ENG-PUDSP20007-R4-PDRFDR.pdf Markup Summary

EMERGENCY SPILLWAY CROSS SECTION B-B
SCALE: N.T.S.

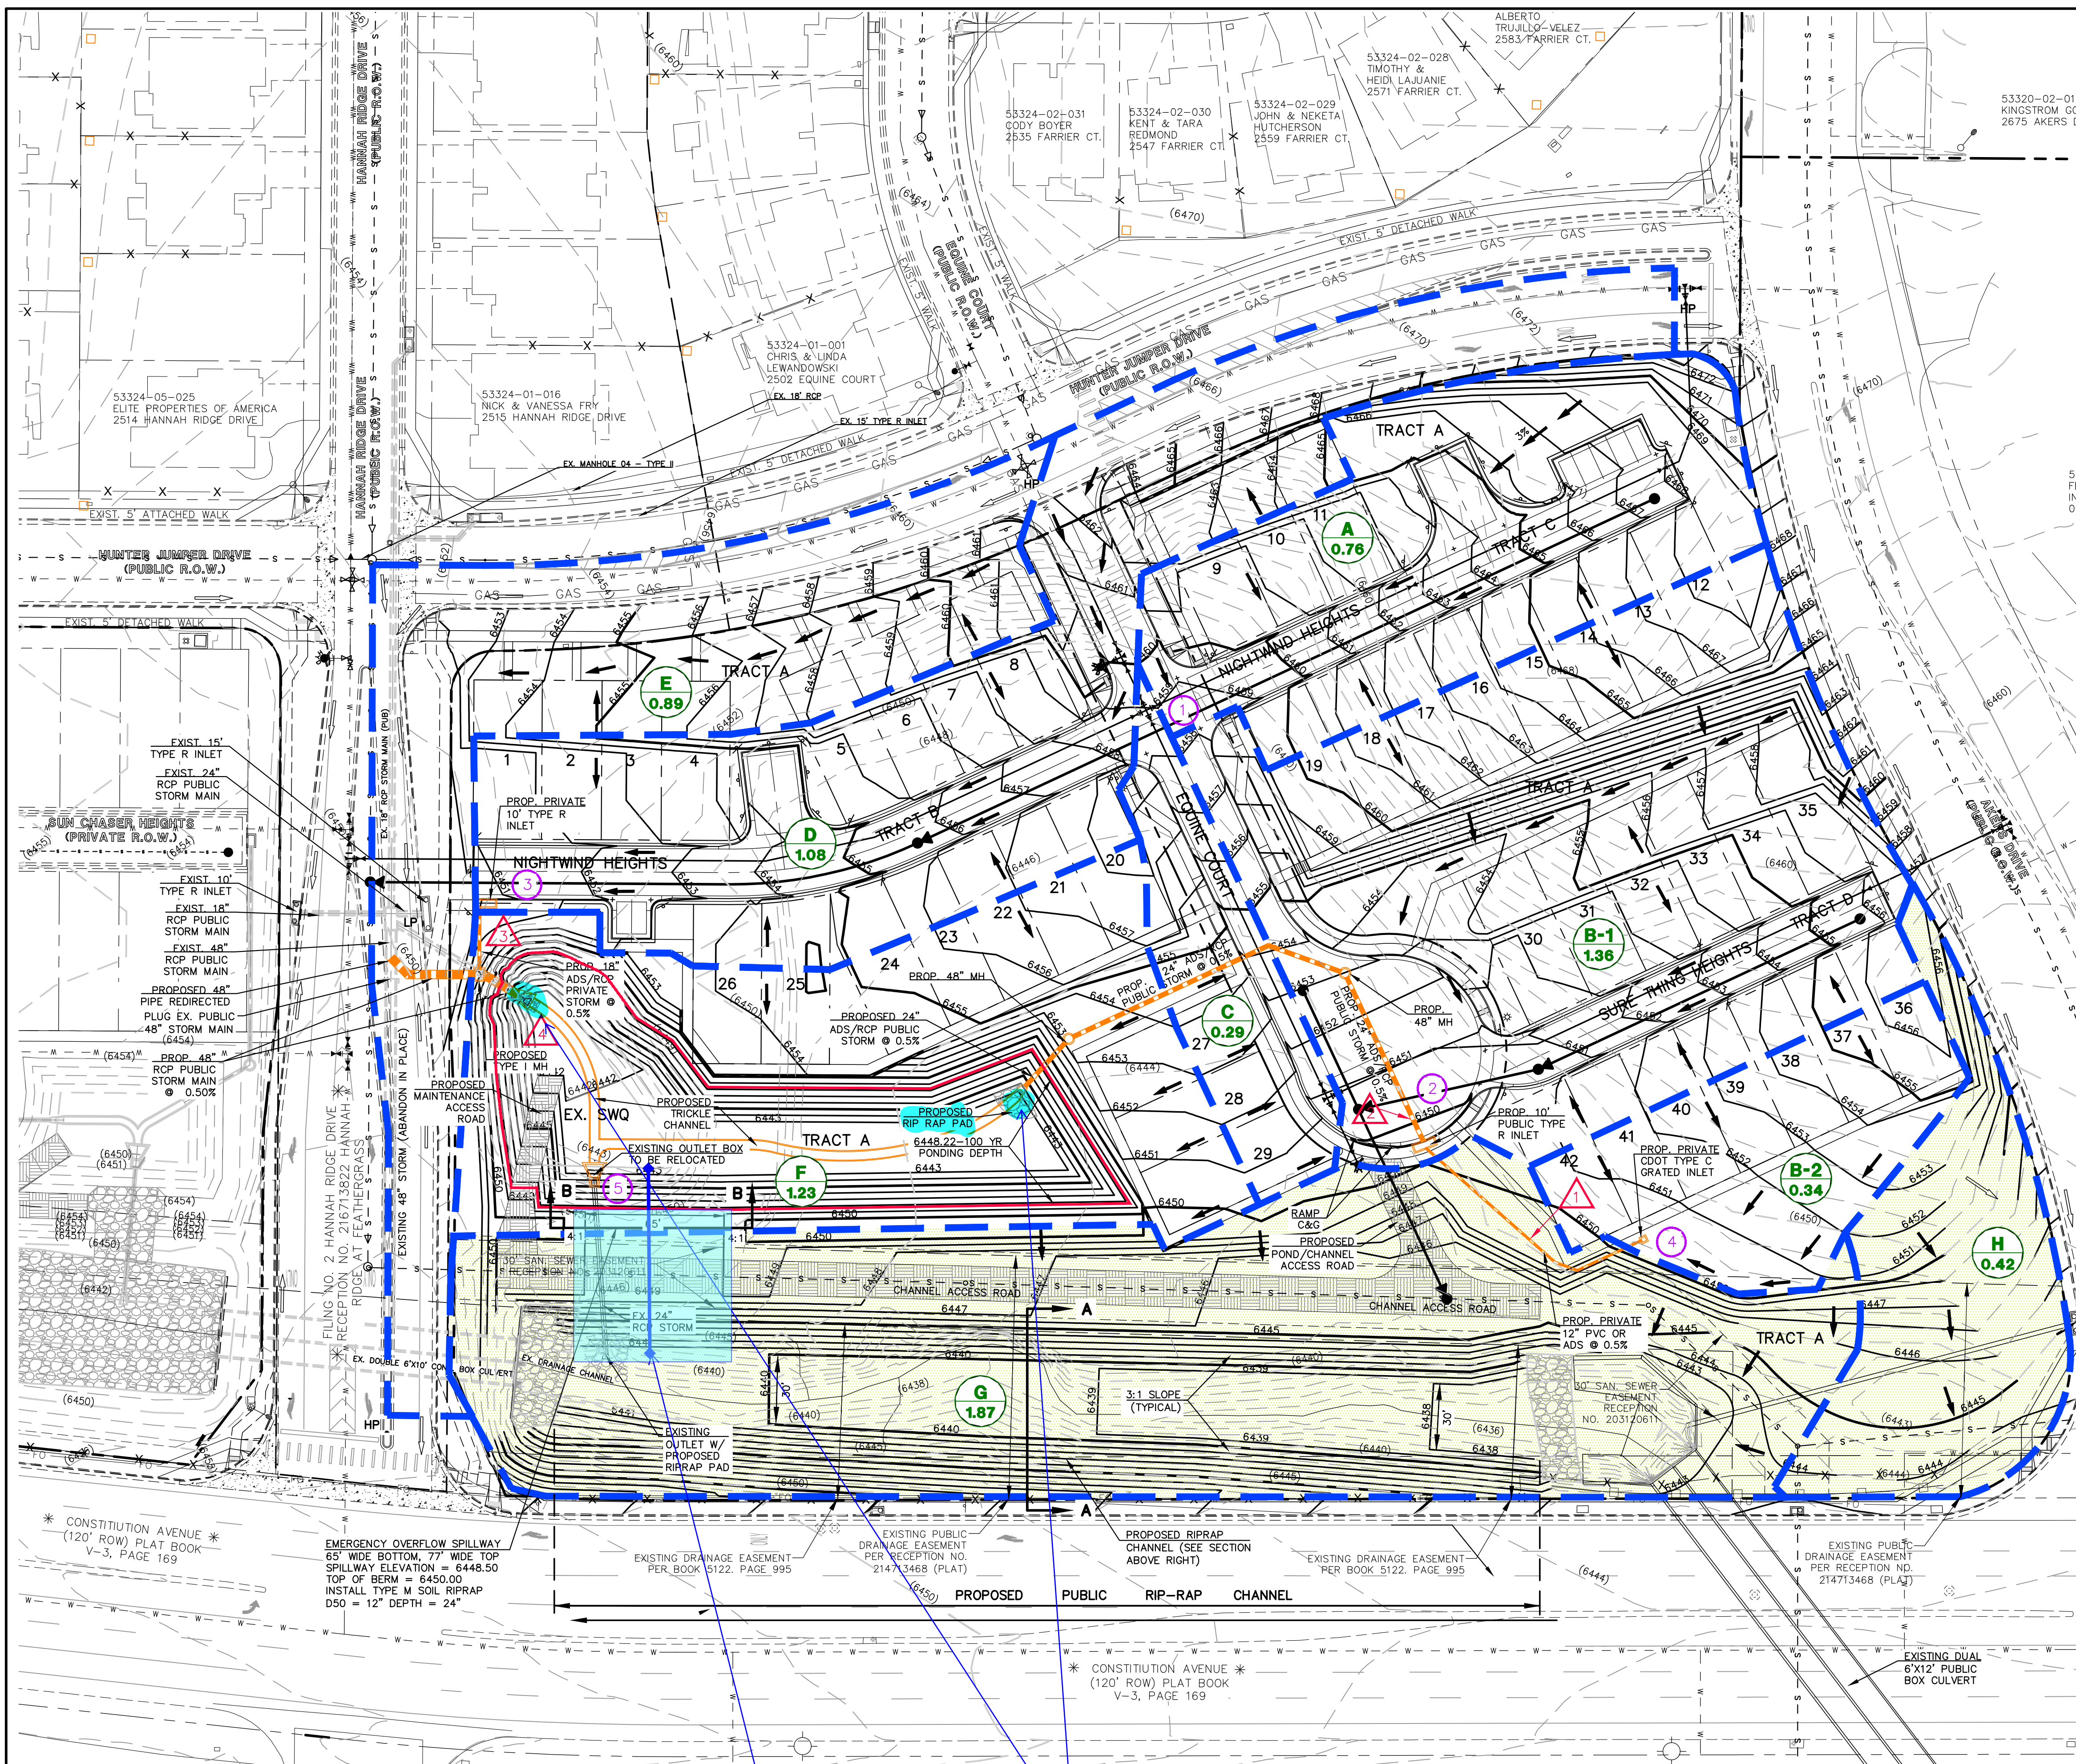
Add a label describing the channel improvements and a cross-section of the channel

Provide dimensions and cross-sections of the spillway. Final design details and calculations are needed since this is a final drainage report.

What happened to the gas line previously shown here?

MIDTOWN COLLECTION AT HANNAH RIDGE
FILING NO. 3
DEVELOPED CONDITIONS DRAINAGE MAP

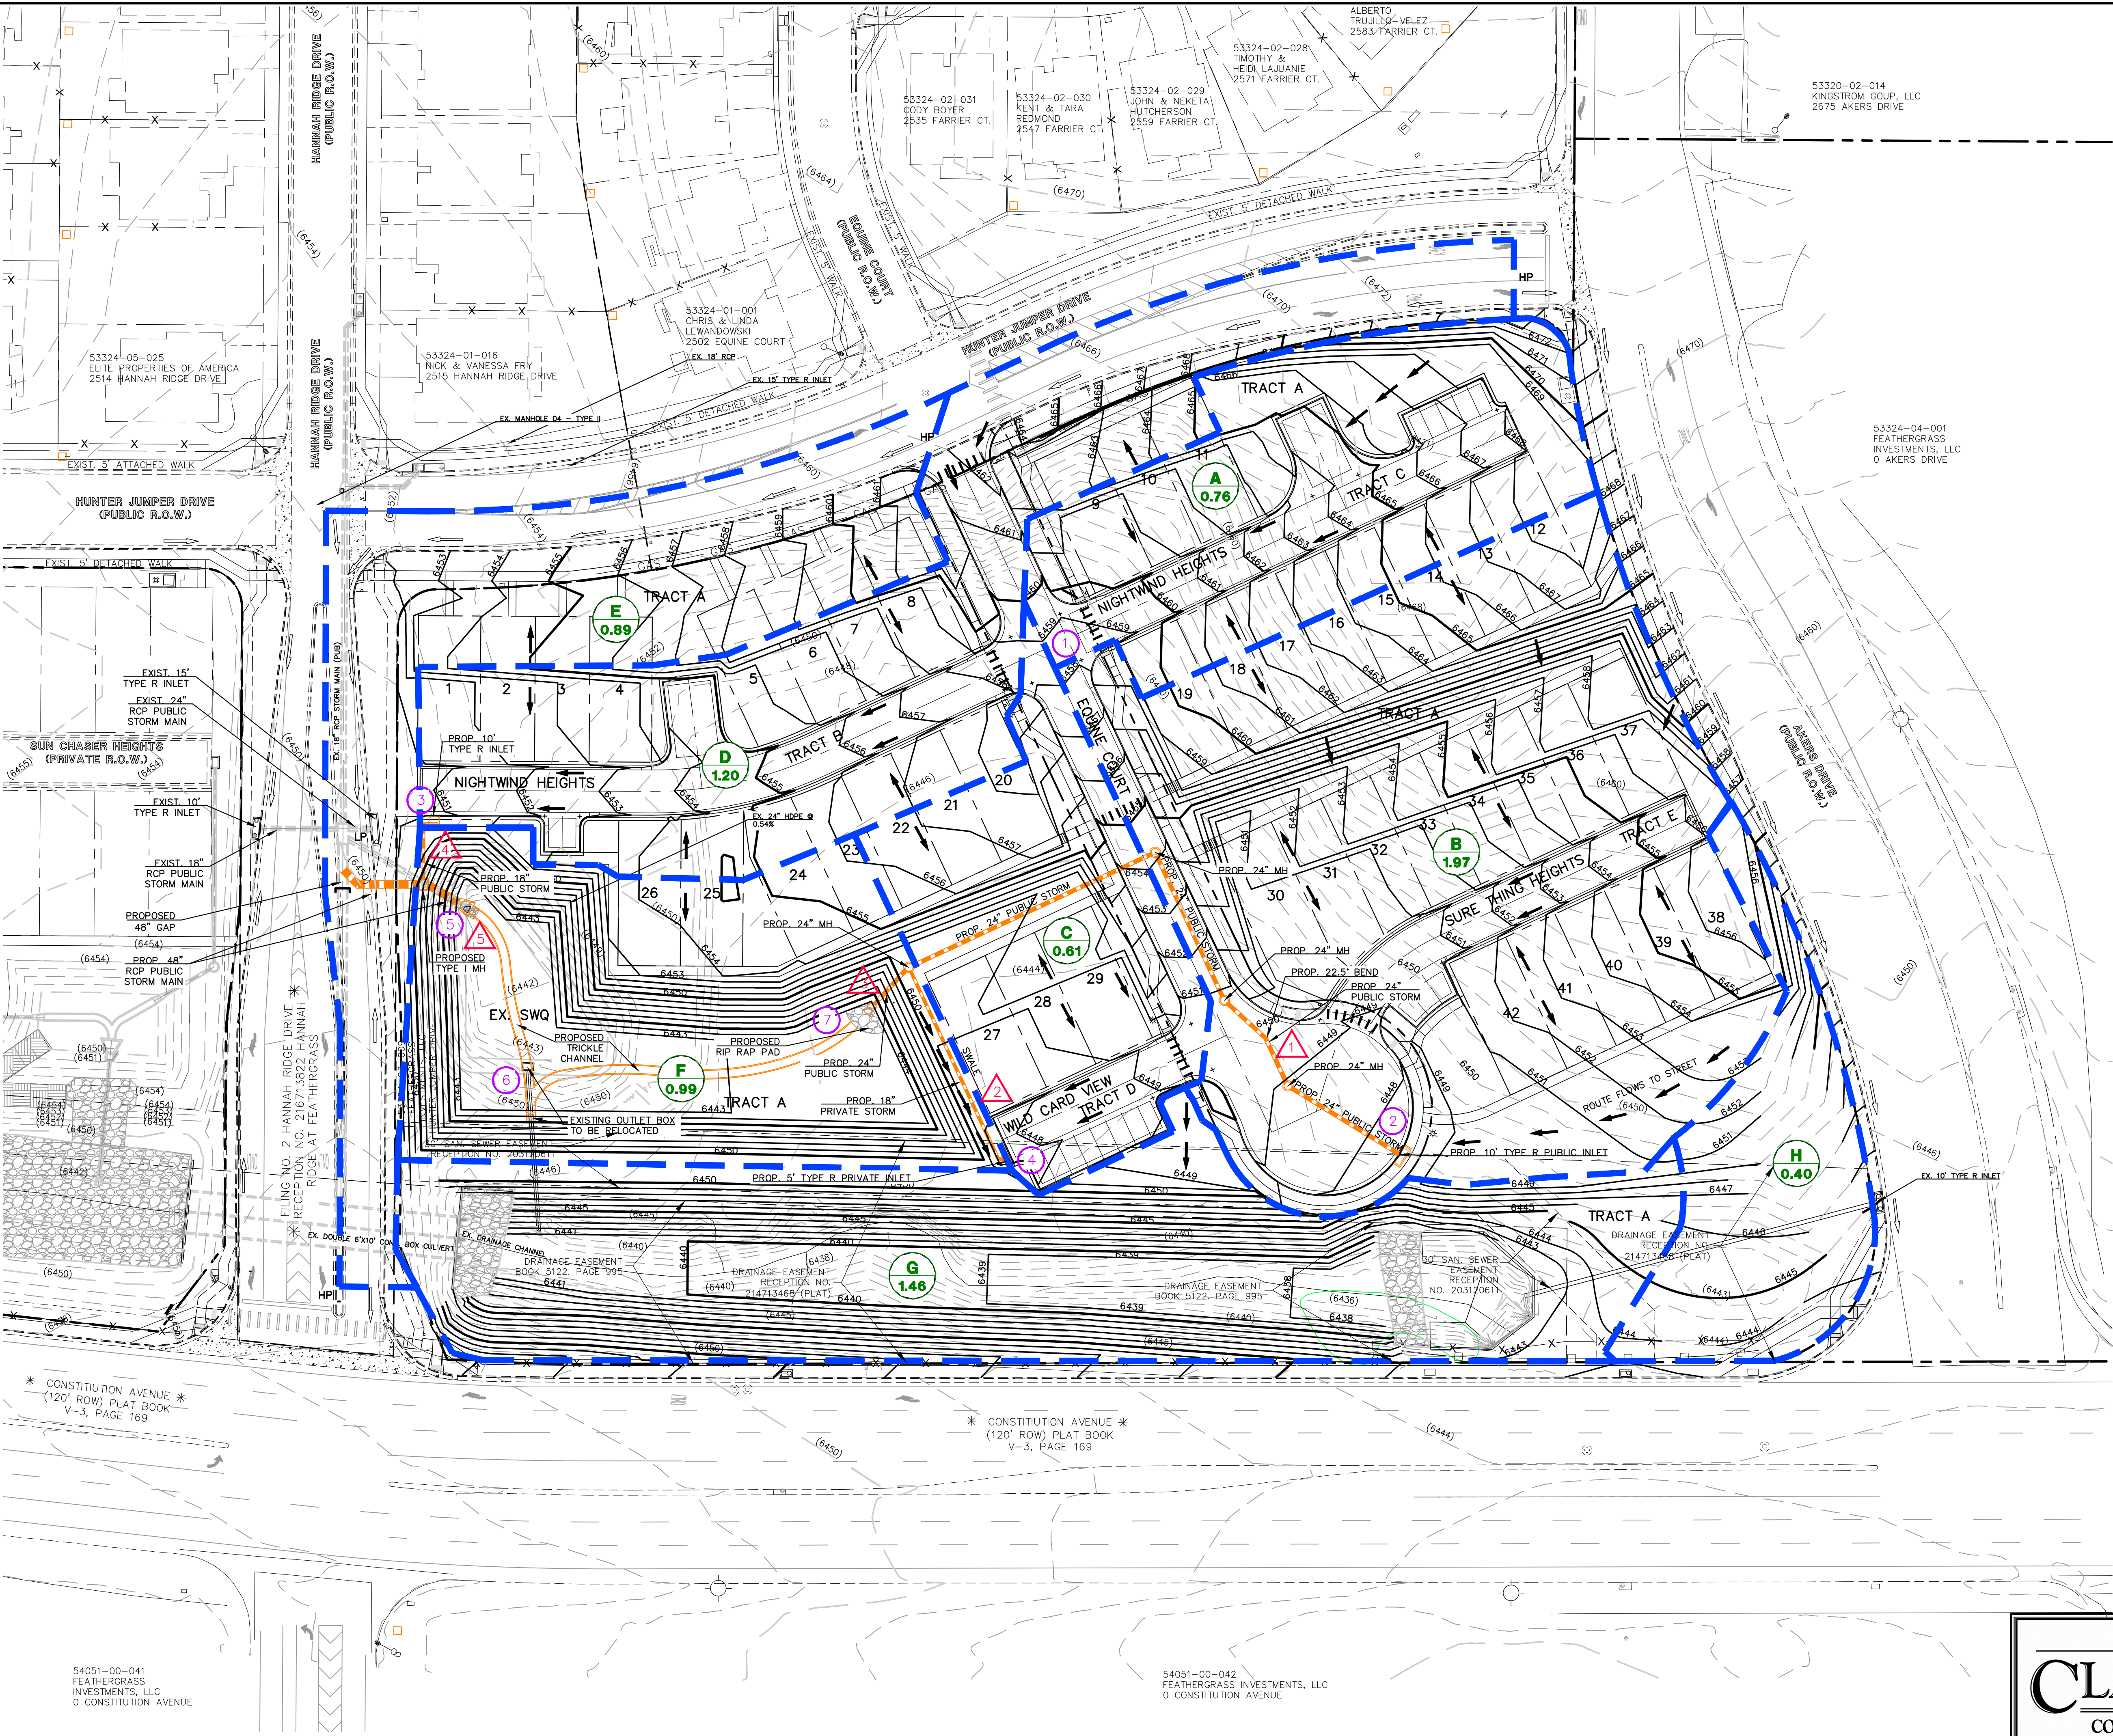
The pond needs to be based on HSG A which calculates the required release rates based on existing soil types
